West Burton ExA Qs1 Deadline 3 Historic England responses in *italics*.

Figure App.13.5-7:
ZTV from Roman villa W of Scampton Cliff Farm (NHLE 1005041)

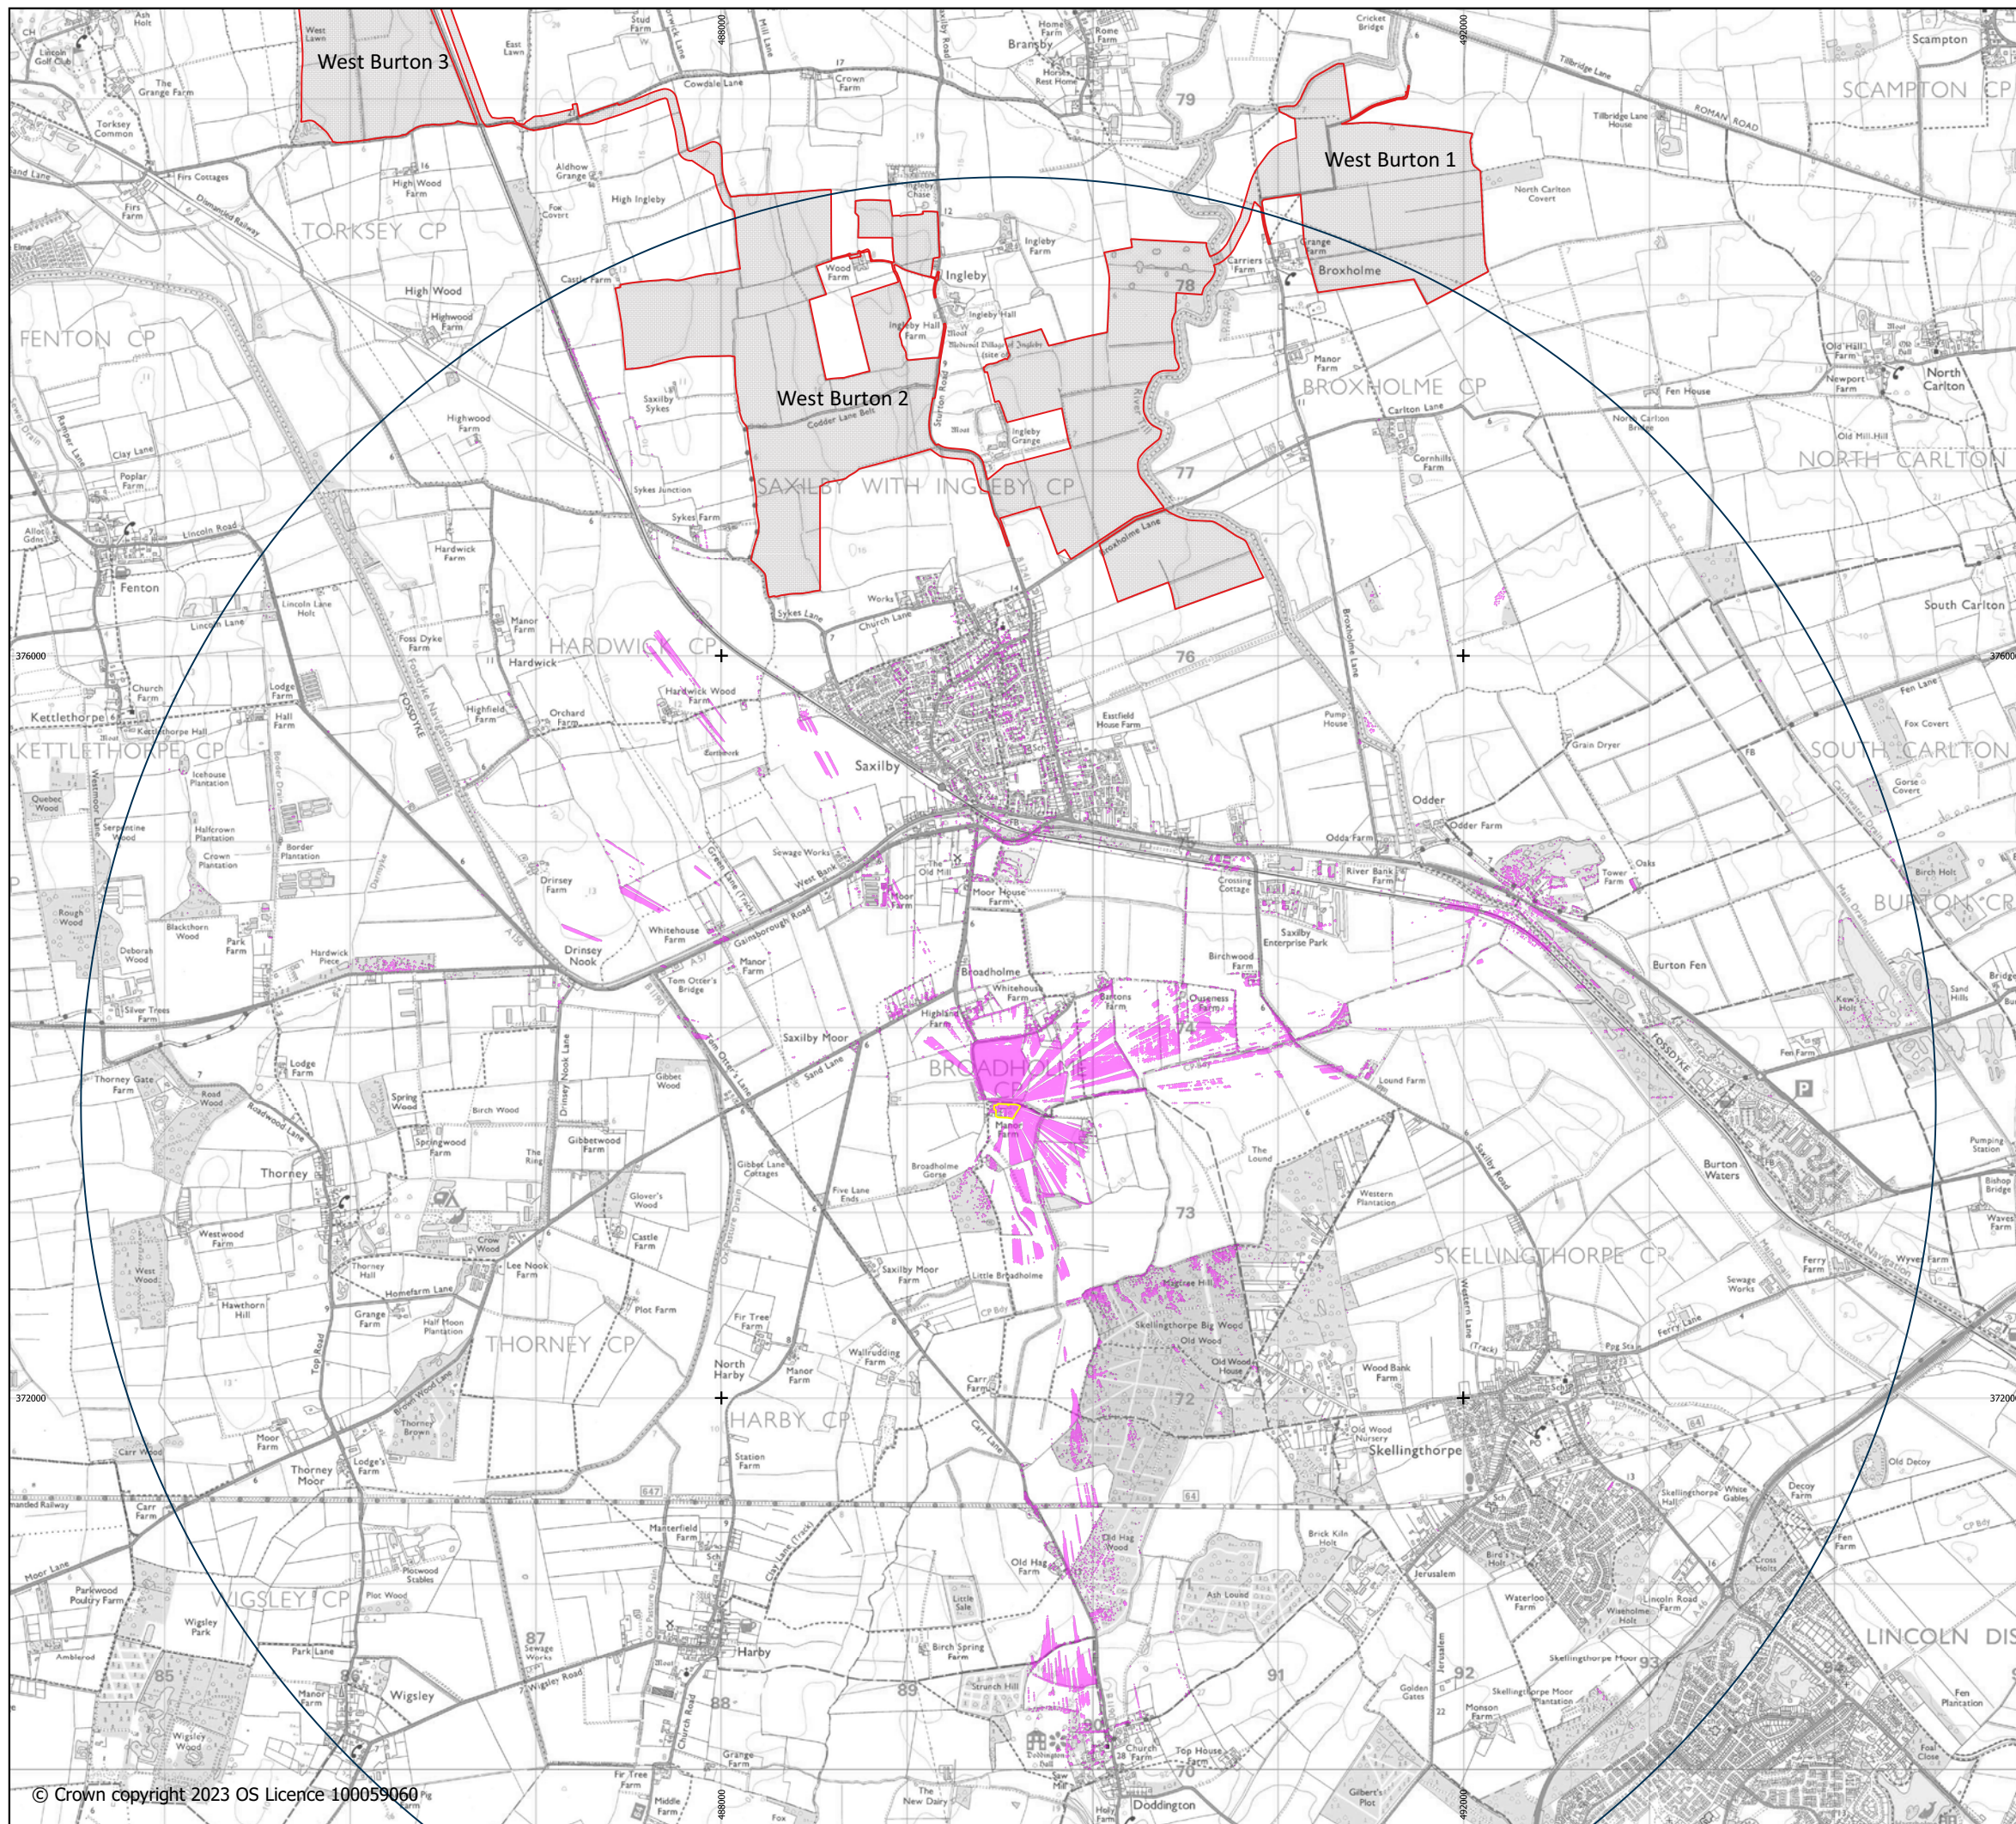
1.7.11	Applicant and Historic England	<p>Roman Villa at Scampton: Cumulative impacts The Potential for up to moderate adverse cumulative impacts with Cottam at Roman Villa west of Scampton (NHLE 1005041) are referred to in the Joint Report in Interrelationships [REP1-057], depending upon the effectiveness of the landscape mitigation. The Heritage Statement [APP-117] at 3.2.14 notes the ‘sweeping view west across the Trent Valley’ from this location, also the Cumulative Developments Augmented ZTV [APP-272] illustrates that all four solar developments would be visible from this location. The Heritage Statement notes a slight adverse effect on significance at 3.3.15, presumably based on the effect of the West Burton Proposed Development alone. However, at 3.3.16 reference is made to fact that as the development would prevent any further developments from occurring within the Order Limits (e.g., for residential development) during the operational period, there is the potential for the Scheme in the longer term to have a beneficial effect on the settings of heritage assets. The Applicant is therefore asked to please explain the implications of these differential assessments. Historic England is invited to comment on both the assessments undertaken and their outcomes.</p>

<p><i>Setting impacts upon Scampton Roman Villa from the present scheme and cumulatively with other NSIP solar proposals currently under examination are suggested by the ZTV. These impacts would derive from change to the landscape character extending west to the Trent. Harm to the monument’s significance would derive from loss to the agrarian character and legibility of that landscape as historic landscape context to the Villa. The assessment in the Joint Report in Interrelationships [REP1-057] appears reasonable. The experience of this landscape as setting forms parts of the general large-scale cumulative landscape effects in the delivery of renewable energy generation with proportionate public benefits, a matter in which we defer to the ExA. We would not give weight to any potential effect of the present proposals in excluding as yet un-drawn developments which might otherwise be brought forwards (to be assessed on their own merits).</i></p>
